Re: Carrillo Shop
1001 Old Coors SW
Traffic Circulation Layout
Engineer's Stamp 06-13-22 (L11-D010)

Based upon the information provided in your submittal received 09-16-22, the above referenced plan cannot be approved for Building Permit until the following comments are addressed:

PROPOSED
TRANSPORTATION
PLAN

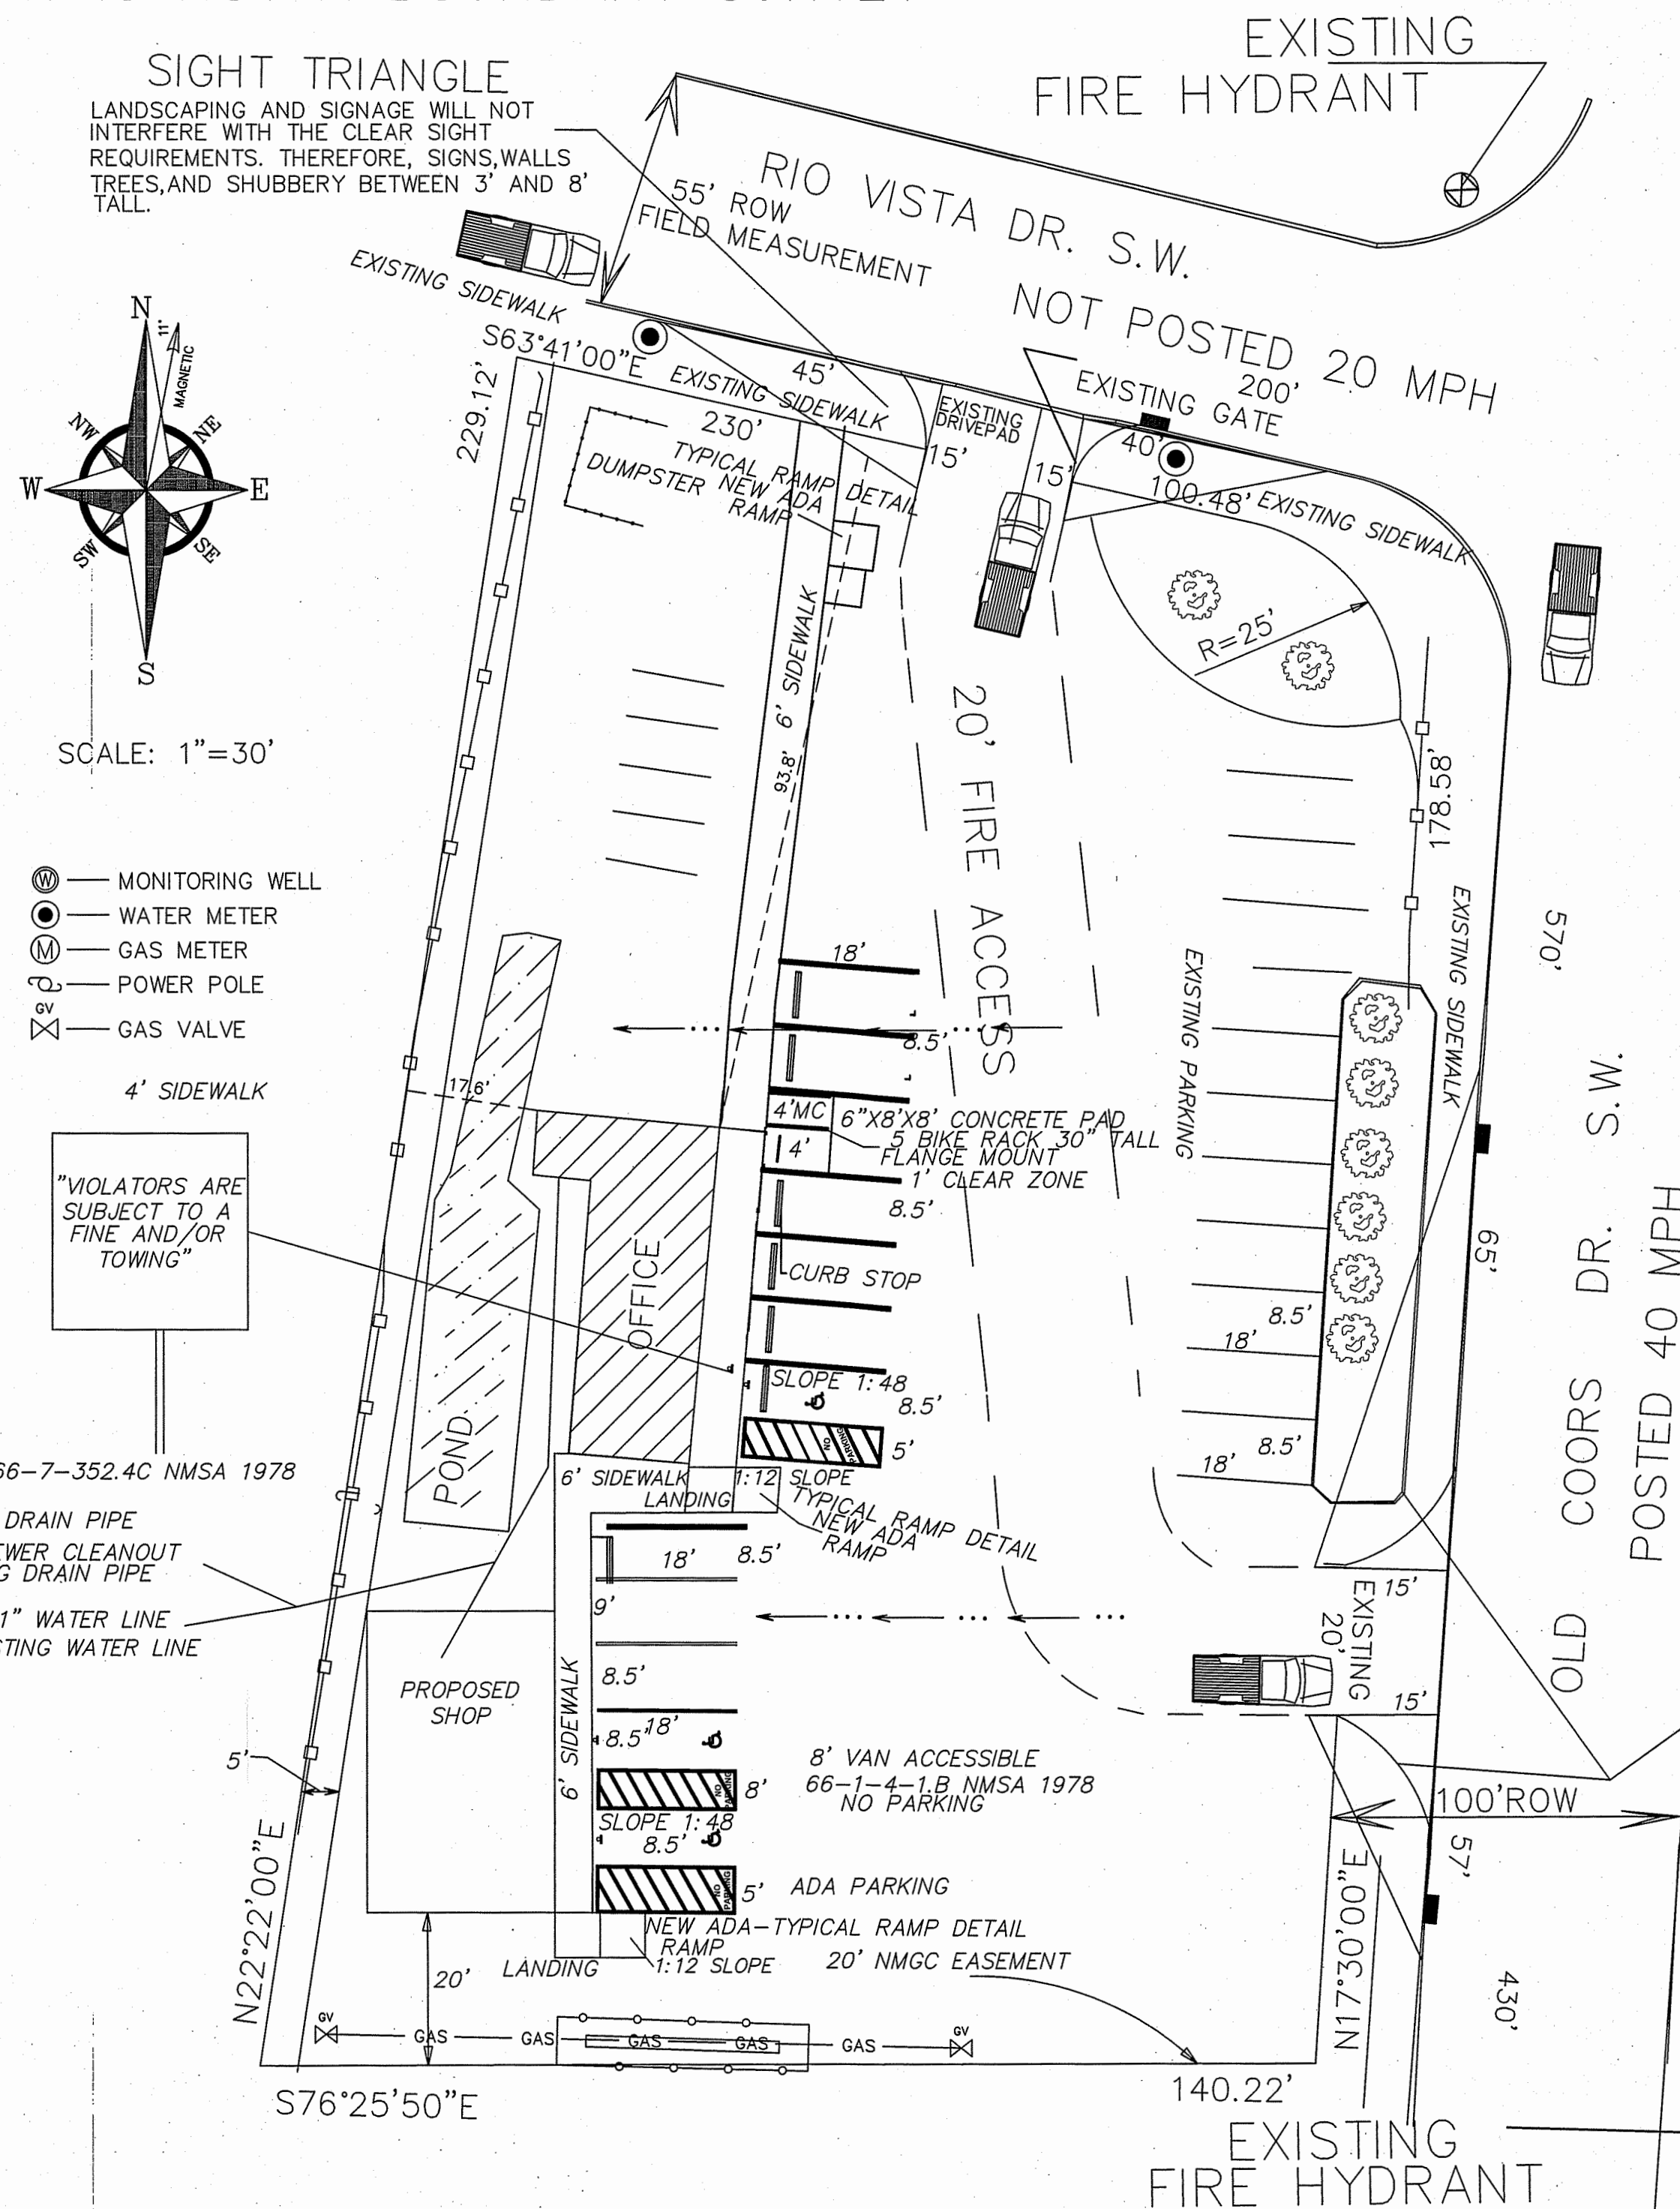
1. Identify all existing access easements and rights of way width dimensions, and provide the width for the existing sidewalk.
2. Identify the right of way width, medians, curb cuts, and street widths on Old Coors Dr.
3. Curb Return design need to be provided for both access driveways off Old Coors and Rio Vista Dr.
4. Clarify existing property lines and proposed property lines.
5. Access width for arterial, collector, and local streets are as follows:

6. Old Coors classified as Minor Arterial, and Rio Vista classified as Local street.
7. ADA curb ramp at the corner of Old Coors Dr. and Rio Vista Dr. must be updated to current standards and have truncated domes installed.
8. Please provide Motorcycle sign details.
9. Show all drive aisle widths and radii. Some dimensions are not shown.
10. The minimum drive aisle dimensions are shown below

11. List radii for all curves shown; for passenger vehicles. Radius for delivery trucks, fire trucks, etc. is 25 ft. or larger.
12. Per the IDO, a 6 ft. wide ADA accessible pedestrian pathway is required from the public sidewalk to the building entrances. Please clearly show this pathway and provide details.

13. Per DPM, a 6 ft. wide ADA accessible pedestrian pathway is required from the ADA parking stall access aisles to the building entrances. Please clearly show this pathway and provide details.

14. ADA accessible pedestrian pathway should not be placed behind parking space or adjacent to a vehicular way. Vehicle and pedestrian/wheel chair conflicts should be avoided as much as possible.

15. Curbing should be installed to delineate landscape, parking, and pedestrian ways and identify points of access. Please call out detail and location of barrier curb.

16. Parking areas shall have barriers to prevent vehicles from extending over public sidewalk, public right-of-way, or abutting lots.
17. Refuse vehicle maneuvering shall be contained on-site. The refuse vehicle shall not back into the public right of way.; provide a copy of refuse approval.

18. Provide a copy of Fire Marshall approval.
19. It is not apparent what type of pavement surface is being proposed. A hard driving surface will be required as part of this proposed project for parking area and drive aisles.

20. Please provide a sight distance exhibit
21. Show the clear sight triangle (on the site plan) and add the following note to the plan: "Landscaping and signage will not interfere with clear sight requirements. Therefore, signs, walls, trees, and shrubbery between 3 and 8 feet tall (as measured from the gutter pan) will not be acceptable in the clear sight triangle.

22. Please specify the City Standard Drawing Number when applicable.
23. Add a note stating "All broken or cracked sidewalk must be replaced with sidewalk and curb & gutter." A build note must be provided referring to the appropriate City Standard drawing.
